re: Grading Plan Review
Proposed High-Rise Building
2145 Walkely Road – Ottawa, Ontario
to: LS GP Inc. – Vincent Denomme – vdenomme@urbandale.com
date: March 24, 2025
file: PG4440-MEMO.01

Grading Plan Review

- ❑ Grading Plan – CAD File: 28584 C G1-ext.dwg, Received March 23, 2025.

File Location: P:\2800028584-000 - 2145 Walkley Road\5-Production\1-Civil\28584 C.G1.dwg

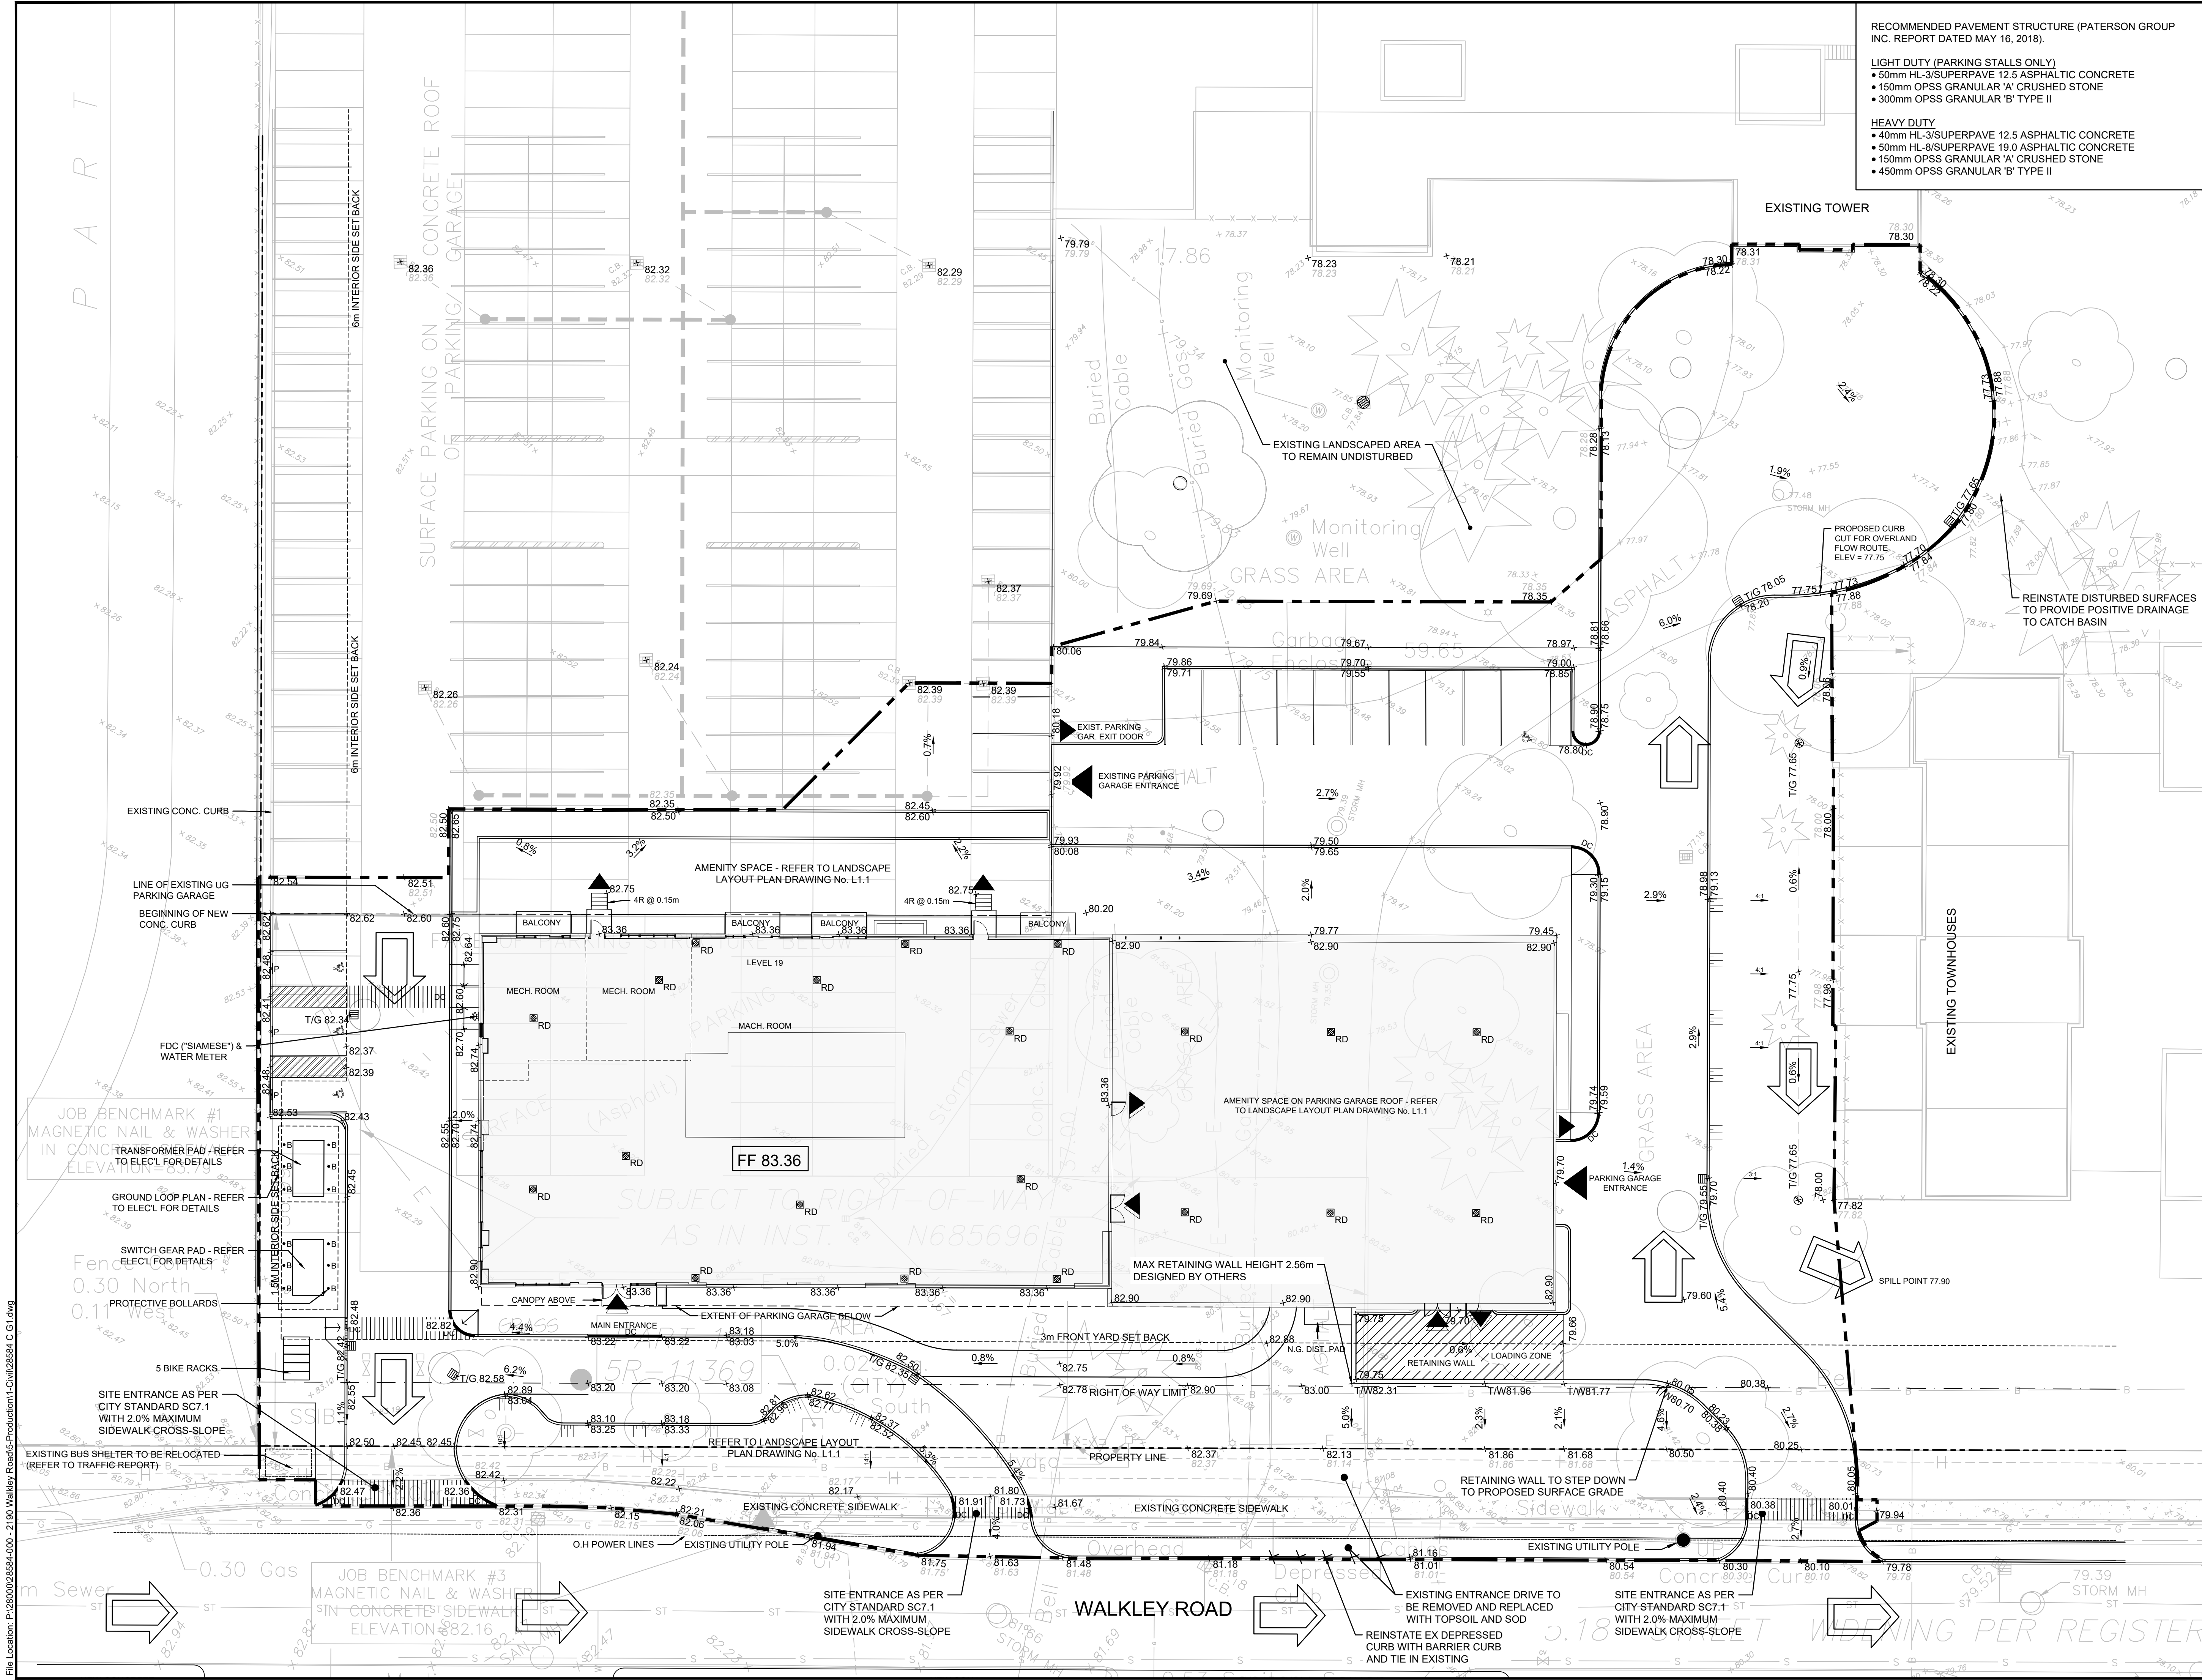
Based on our review of the aforementioned grading plan, the proposed grades around the proposed building and throughout the subject site are within the 2 m permissible grade raise restriction provided in the aforementioned geotechnical report.

Based on this, the proposed grading is considered acceptable from a geotechnical perspective and would not require the use of lightweight fill to accommodate the proposed grades.
